October 5, 2023

Re: Insight Construction
3821 12th St. NW
30-Day Temporary Certificate of Occupancy
Transportation Development Final Inspection
Engineer's Stamp dated 05-17-21 (G14-D096)
Certification dated 10-02-23

Based upon the information provided in your submittal received 09-27-23, Transportation Development has no objection to a 30-day Temporary Certificate of Occupancy based. This letter serves as a "green tag" from Transportation Development for a 30-day Temporary Certificate of Occupancy to be issued by the Building and Safety Division.

Number: **C100**

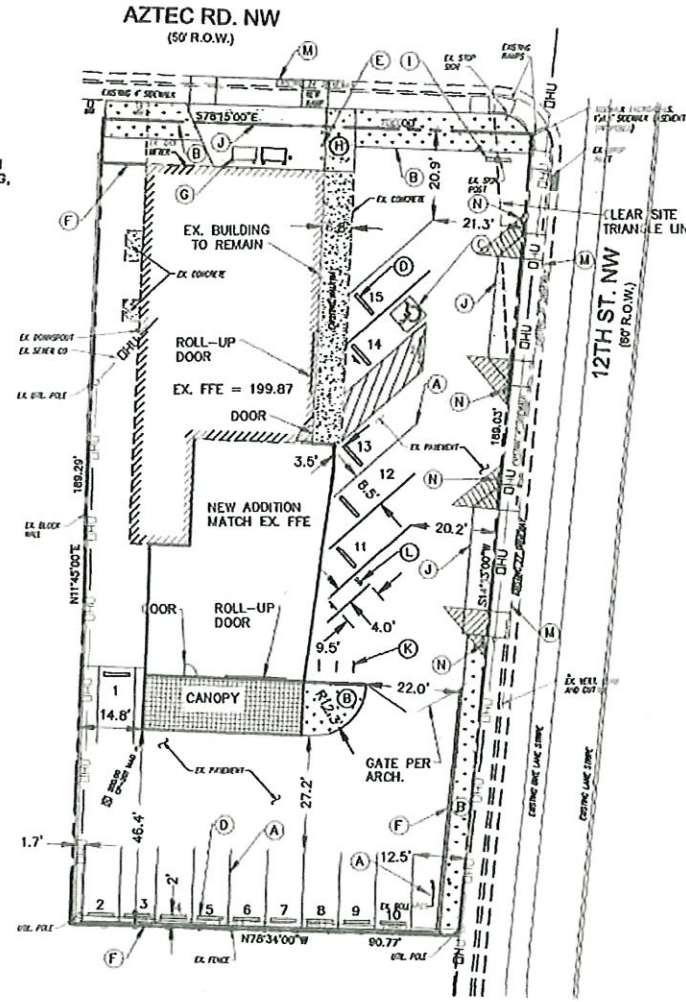
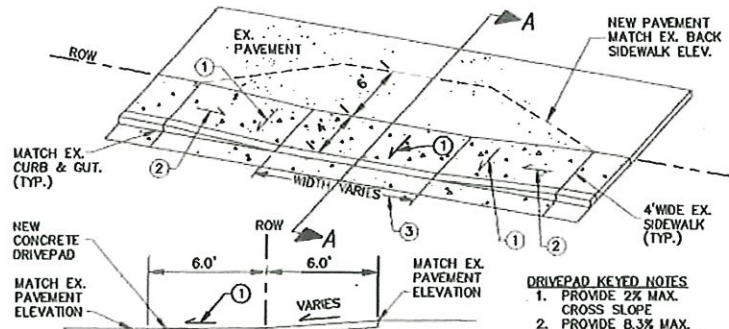
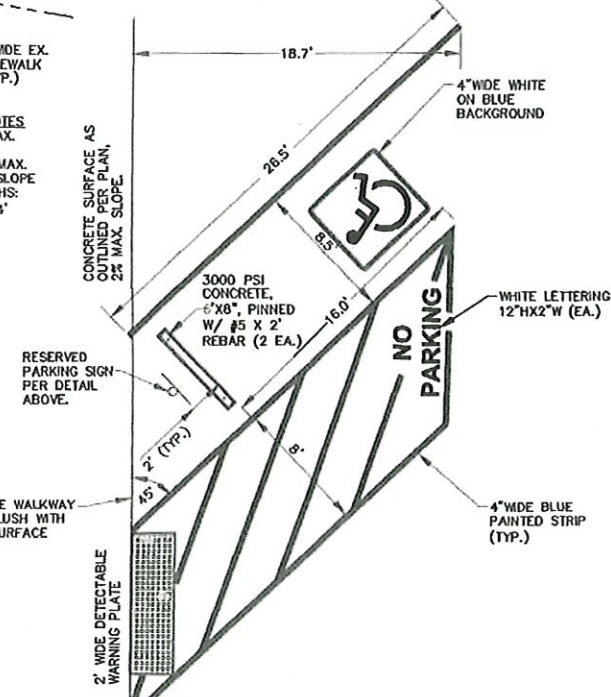
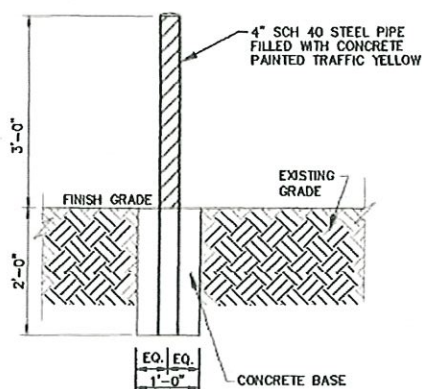
- Per the approved plan, please install concrete parking bumpers in the ADA parking stall.

- Keynote N: Per approved plan, All one-way drives shall have "One Way" and "Do Not Enter" signage and pavement markings. Please install the signs.
- Please provide a minimum 4 ft. wide ADA pathway around the south site access. As a suggestion: please consider installing a 4'X4' concrete pad on the south side of the access, to create an ADA compliant pathway.
